7000 Acres

7000 Acres Response to the West Burton Solar Project Ltd Application on the subject of:

Agricultural Land Classification

Deadline 1A Submission – 7th December 2023

Grade 3b

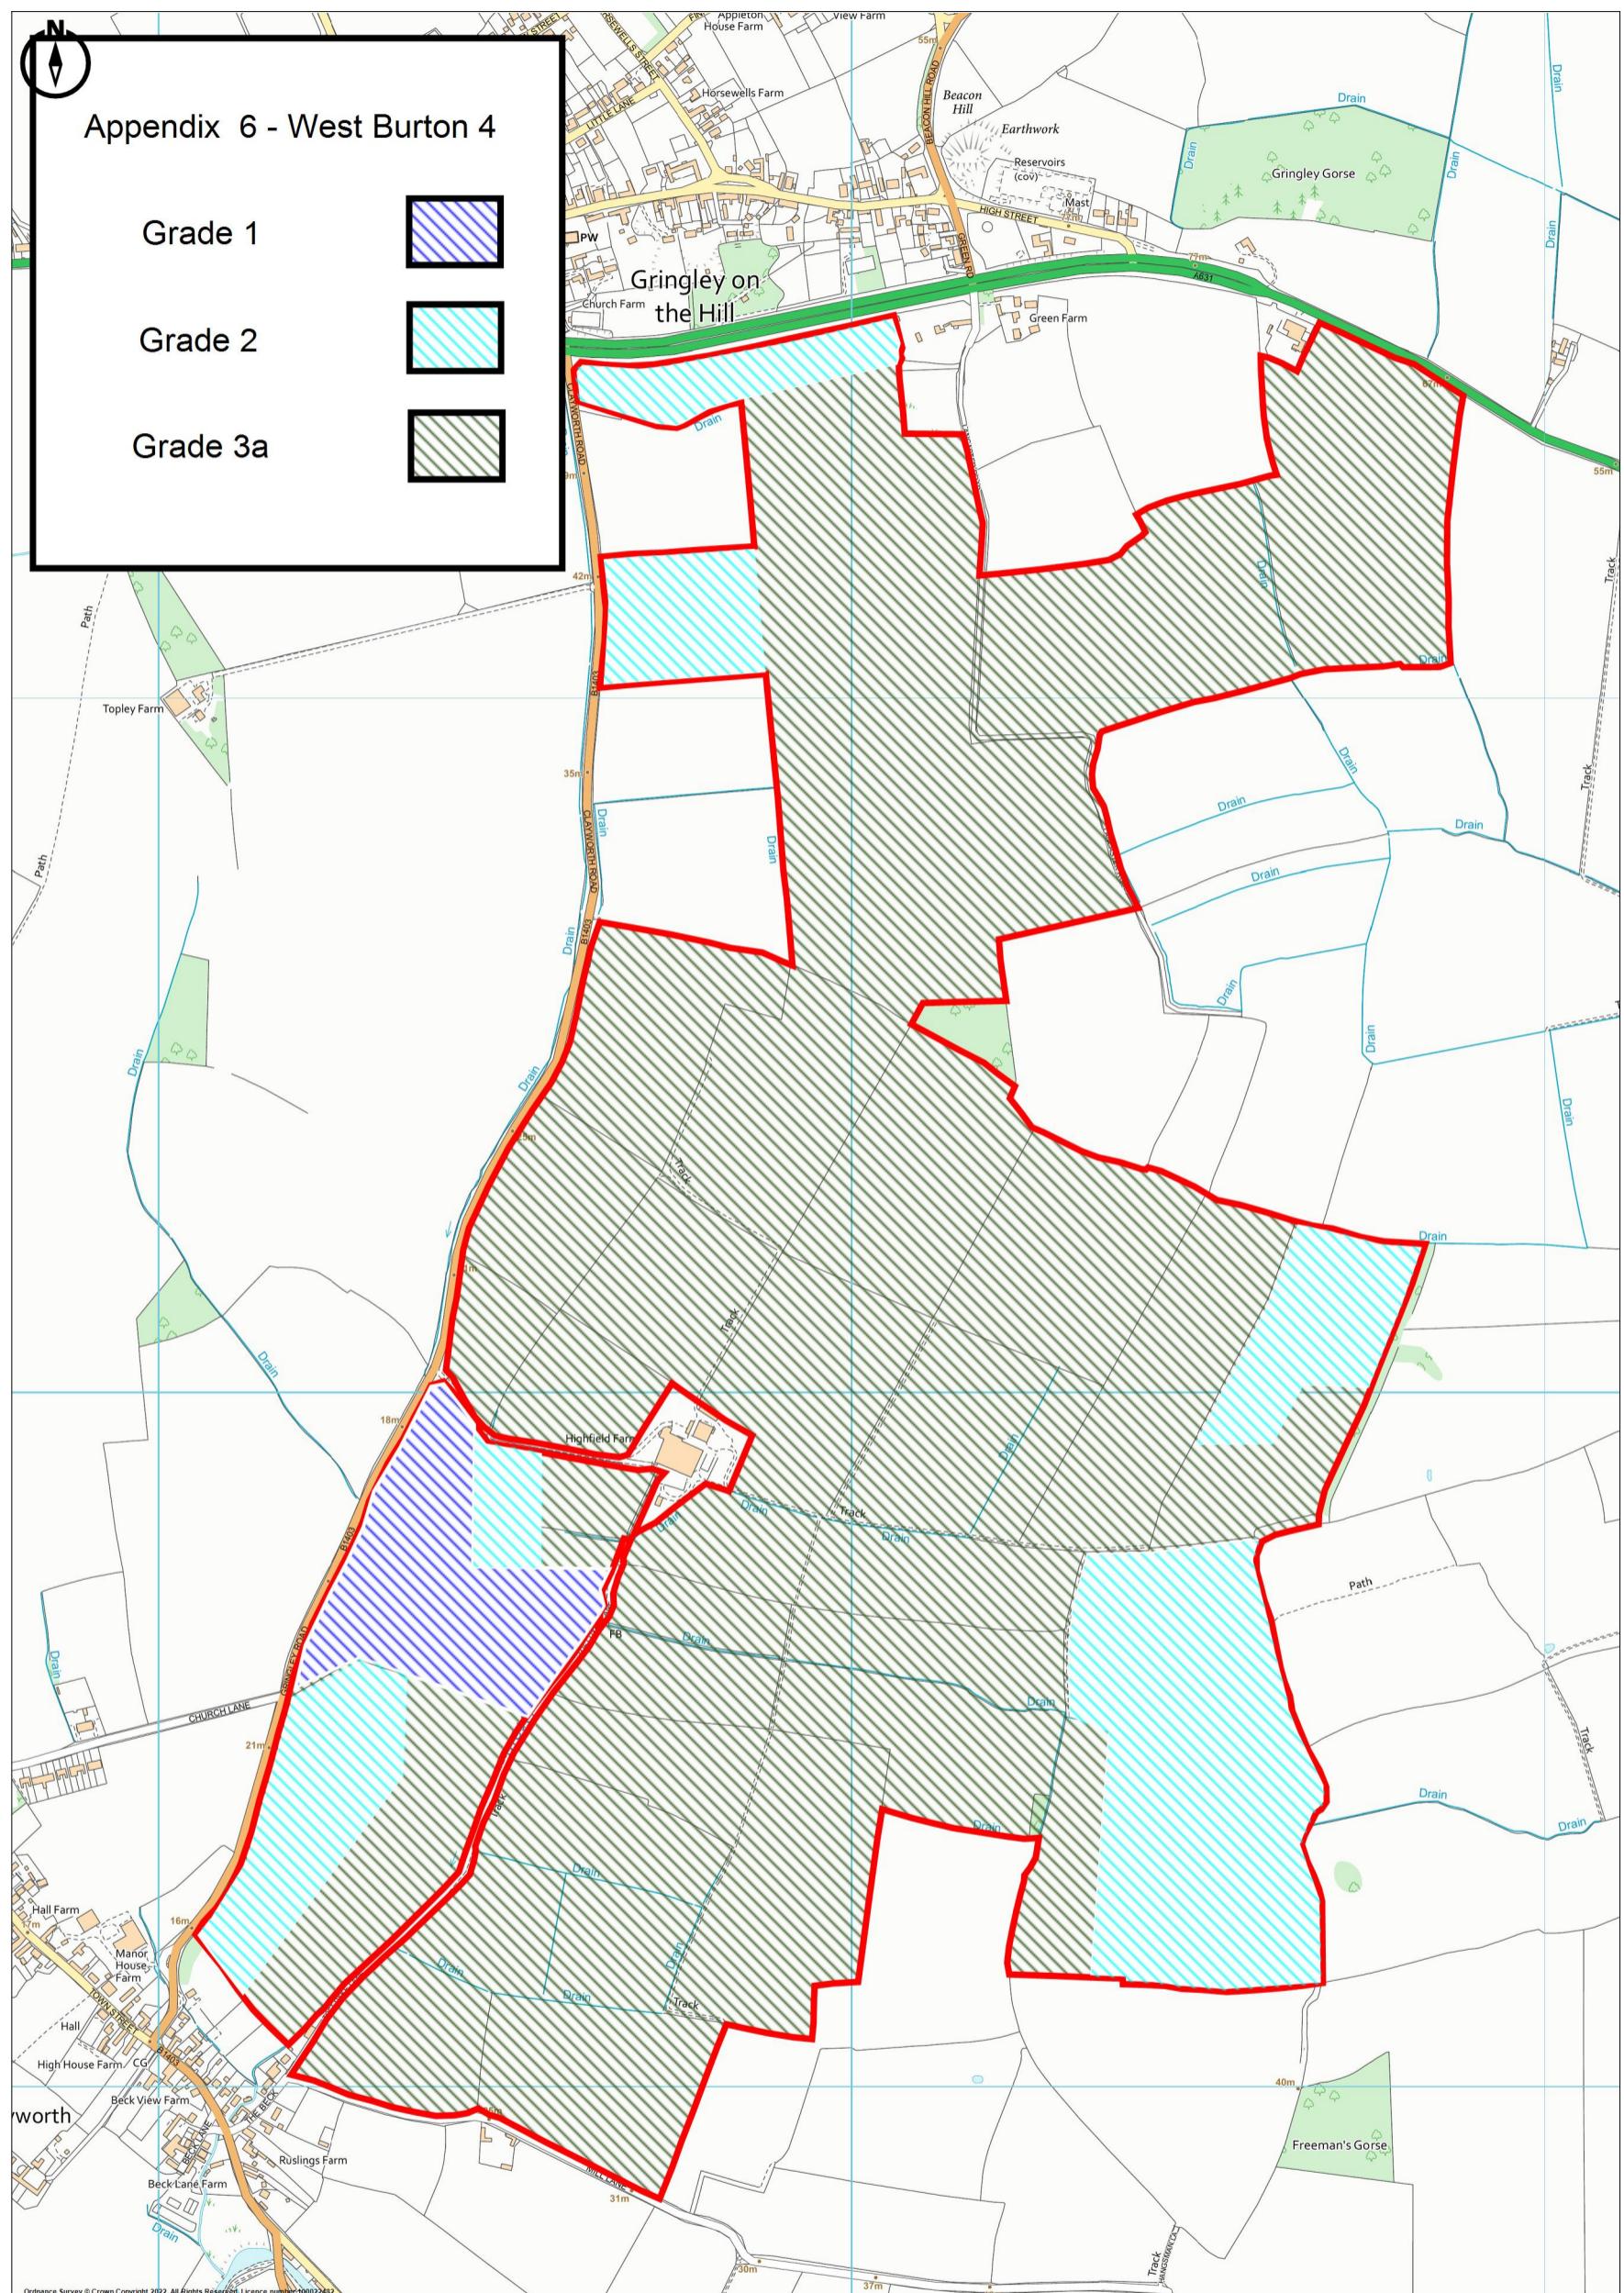
When analysing the submitted ALC data in detail, contained in APP-137 Environmental Statement, Appendix 19.1 Agricultural Land Quality, Soil Resources & Farming Circumstances March 2023, the following inconsistencies and inaccuracies can be found:

Variances of Grade with similar data results:

Sample	Grade	Sample	Grade
450, 451	2	295, 306, 307, 308, 309, 322, 323, 324, 325, 326, 327, 336, 337, 338, 339, 340, 341, 342, 343, 344, 353, 354, 355, 356, 357, 359, 360, 366, 367, 368, 369, 371, 372, 373, 374, 375, 376	3b

Sample	Grade	Sample	Grade
391, 469	3a	386, 387, 388, 392, 393, 394, 395, 396, 397, 407, 408, 409, 415, 416, 417, 418, 419, 429, 430, 440, 448	3b
968, 998, 1009	3a	759, 760, 774, 775, 795, 796	3b
335	2	334, 597, 605, 613	3b
979, 980, 981, 982, 993, 994	3a	966, 967	3b

The classification of some of the samples has been downgraded based upon allocating the samples to the Wetness category III criteria. The field capacity of the soils shows this categorisation can be very marginal.

In addition to these records there are 96 samples with missing data in their field records or inaccuracies. A further 36 samples have inconsistencies in their field records. That is **216 records** that require further investigation and adjustment out of a total of **829 samples** i.e. **26% errors**.
